From: Amanda Scholes on behalf of Planning.Responses
Sent: 24 October 2017 08:59
To: Planning Scanning
Subject: FW: LU/282/17/RES - *EXTERNAL: FW: Courtwick Lane - mixed use building

From: Keeley, Nick [REDACTED]
Sent: 18 October 2017 14:38
To: Michael Eastham
Cc: Phillips, Robert (Southern Counties); Withey, Phillip; Nigel Loines
Subject: Courtwick Lane - mixed use building

TITLE  
COURTWICK, LITTLEHAMPTON  
Commercial and Flats

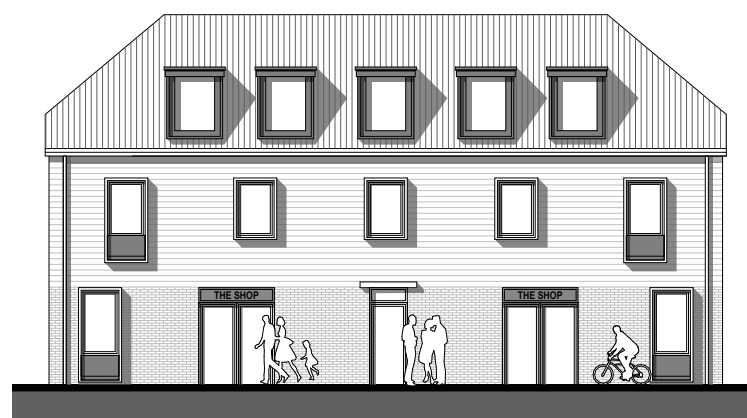
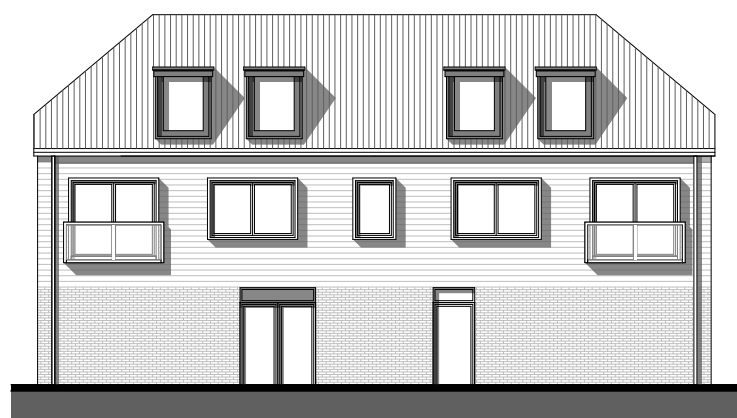
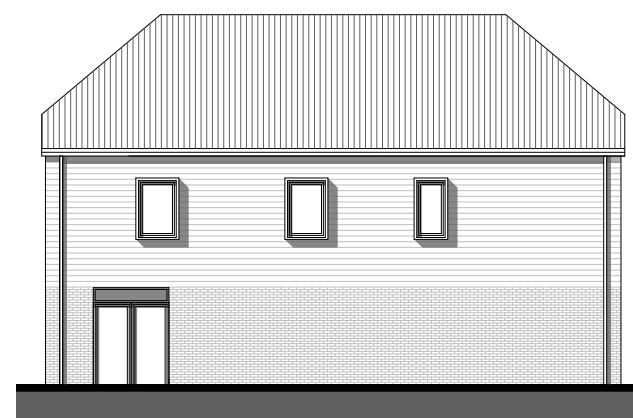
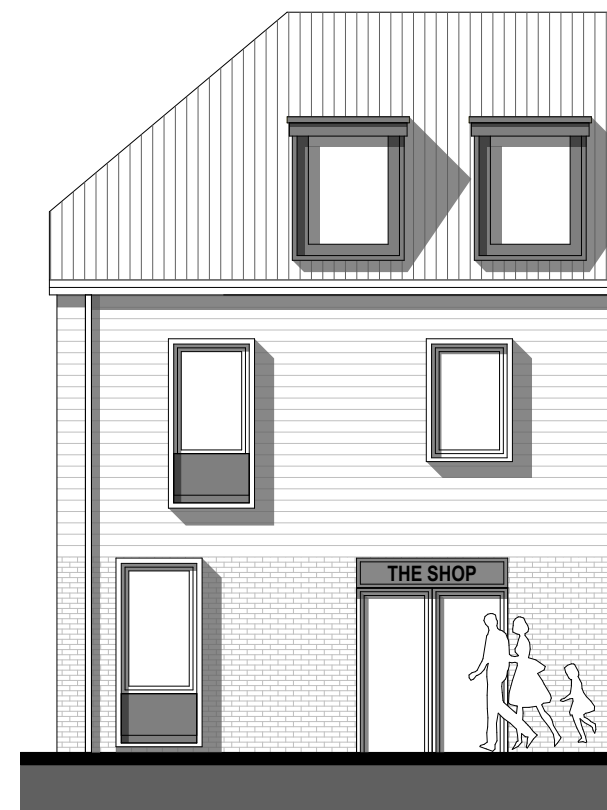
According to the Courtwick Design and Access Statement, it is the stables building that your building should reflect.

I have discussed the proposed amendments to the elevations of the proposed mixed use building with my Team Leader, Claire Potts and it has been resolved that the building itself needs to be re-designed so that it accords with the wording on page 86 of the "Courtwick: A proposed urban extension to Littlehampton Design and Access Statement".

The wording on page 86 says: "At the northern edge of the (Village Green and Communal Centre) character is a mixed use building with apartments over a retail space. In architectural form and detailing, buildings in this character area must suit the scale and materials palette of the existing farm cottages and Court Wick Park. The mixed use building should reflect the stables part of the listed complex, with special wall finishes and a vertical element to the roof."

To that end, HGP have come up with a revised elevational treatment that pulls through materials which were identified as being appropriate in the illustrative Masterplan. These are; the use of dark red/russet multi-stock facing brick, horizontal boarding (matt black stain) and black uPVC rainwater pipes all of which were explicitly referenced in the palette of materials you referred to.
